City of Albuquerque

RE: REVISED-ENGINEER CERTIFICATION FOR FUSION, INC. (M15-D23D)
CERTIFICATION STATEMENT DATED 9/24/92.

RE: ENGINEER CERTIFICATION FOR FUSION, INC. (M-15/D23D) CERTIFICATION
STATEMENT DATED SEPTEMBER 7, 1992

RE: REVISED DRAINAGE PLAN FOR FUSION, INC. (M-15/D23D) ENGINEER'S STAMP WITH
REVISION DATE APRIL 3, 1992

TEMPORARY ASPHALT RUNDOWN DETAIL
N.T.S.

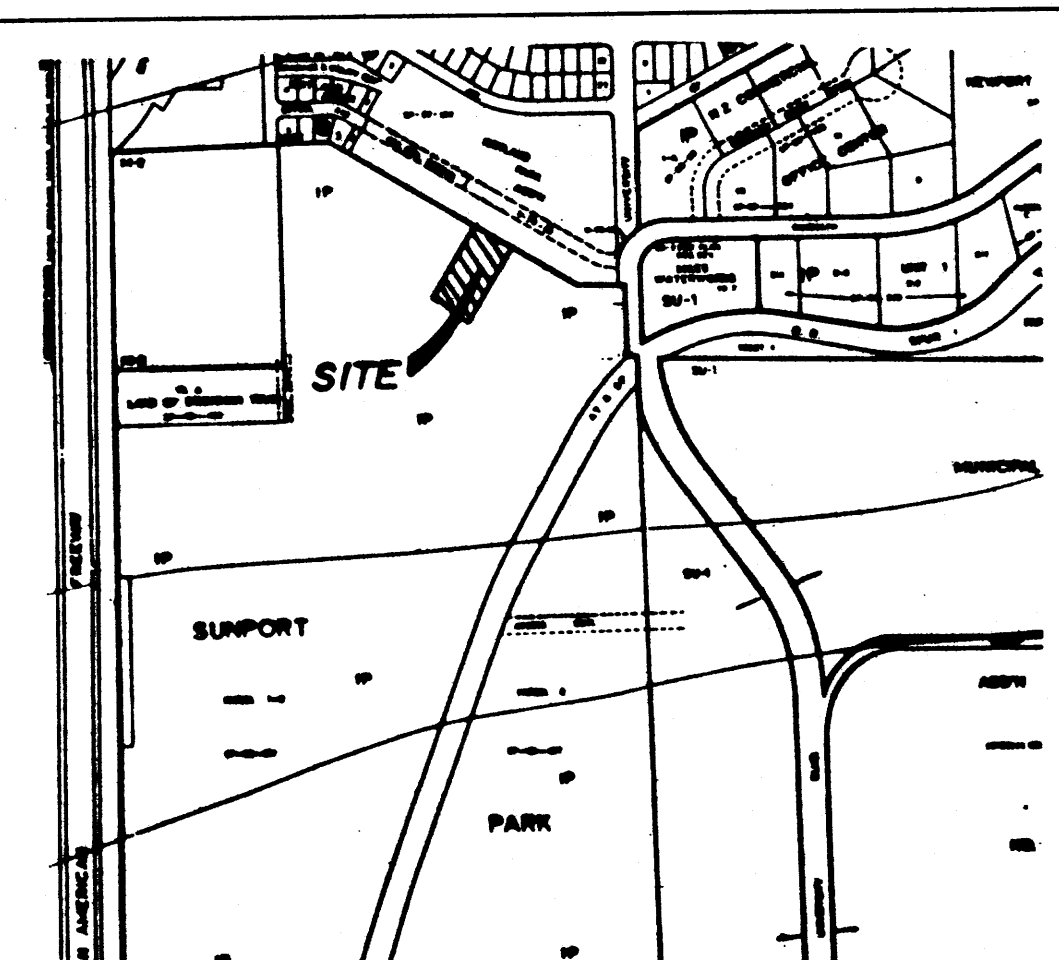
1. Swale on the east side of the property which intercepts the off-site flows is not adequate to handle the flows. A field survey indicated that there exists a low point within the berm which will allow the runoff to be routed towards the west and not the asphalt rundown.
2. Large erosion cuts are evident on the north side from the downsput. The erosion problem must be addressed.
3. Downsput on the northwest corner of building has already caused erosion and sediment onto the swale along the west side of the building.
4. Original approved plan indicates a wall on the northeast corner of the building, wall does not exist.
